Ref Outline Planning application 2020/92331

I am a long term (43years) resident of Chidswell Lane. Although there is no possibility of this overall planning application being rejected, as its been instigated and supported at government, regional and local council levels over the past decade, which is evident from the initial changes in declassification and re-zoning of the area to facilitate this development. I would however like to ask for some changes and rejection to the inclusion of the 4th and additional / new access road junction (ref A 13398-T-005) that will link the new development to Chidswell Lane and the Windsor / Smallwood community.

Predominantly the section of Chidswell Lane that the developers have failed to include in their traffic survey, whilst still identifying it as a route for access and egress to phase 1a of the proposed new development via the new access junction ref A 13398-T-005 on Chidswell Lane in their Framework Travel Plan (FTP) Final Report A13398/VAA11 dated June 2020.

Drawing Title
Proposed Site Access 4 - 97 Chidswell Lane

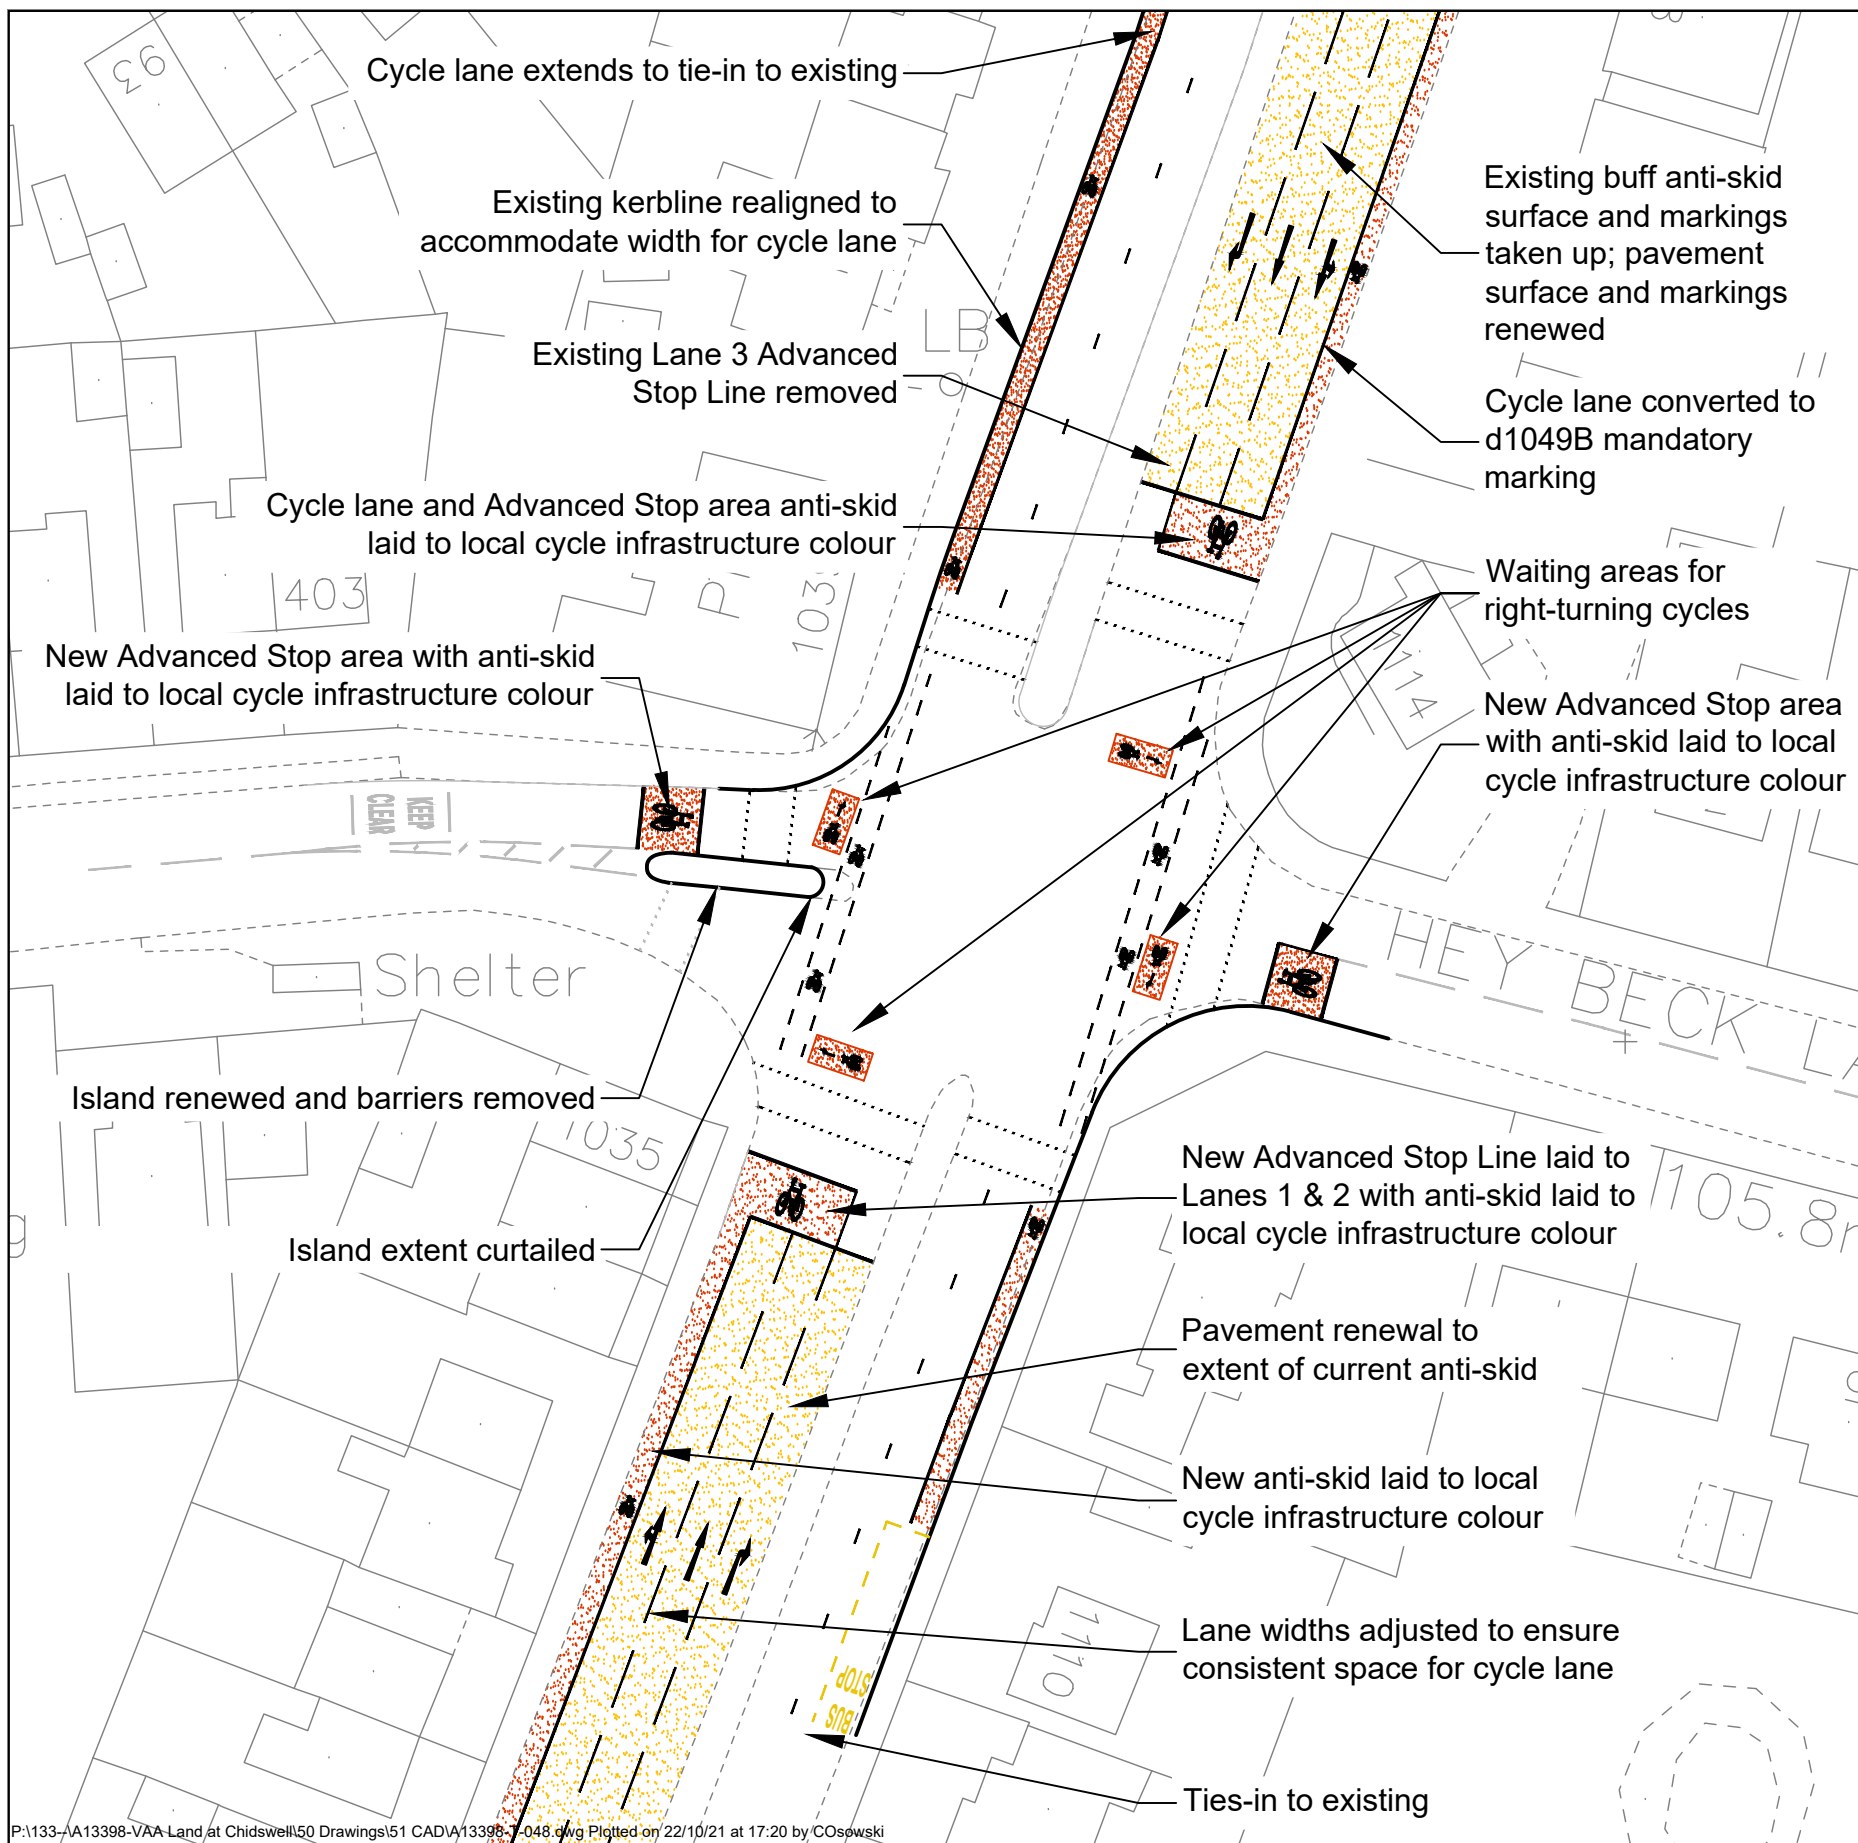
I would like to register my comments and lodge an objection to the inclusion of any linking traffic junction between this new and existing communities as an access point of this development due to the detrimental environmental and safety impacts it will impose to the current Chidswell Lane community by the increase of traffic flow along Chidswell Lane via the proposed junction ref A 13398-T-005 or any other junction linking the two communities will bring.

The placing of an access junctions on Chidswell Lane (REF A 13398-T-005) for this development would severely increase the traffic, congestion, noise and pollution on these roads. Especially, according to the developers supporting surveys and documentation, this is the recommended / suggested route for the residents in phase a1 to access Shaw Cross School, Dewsbury Rail station and other local services with inference to vehicular access / egress towards Dewsbury, Batley, Ossett and all regional and destinations beyond.

The inclusion of this access road junction ref A 13398-T-005 will be to the detriment of the current residents' safety, whilst increasing congestion, noise and emissions of pollutants to the community. This is in conflict of government and local planning guidelines.

I therefore believe that the proposed access 4 onto Chidswell Lane violates this requirement and reiterate my request that the linking of the new development with Chidswell Lane by inclusion of the proposed new access road (ref A 13398-T-005) be reviewed and rejected, and that any form of access to this proposed new development should be direct to the main highway network only and not through or via the existing Chidswell, Windsor and Small Wood Road community.
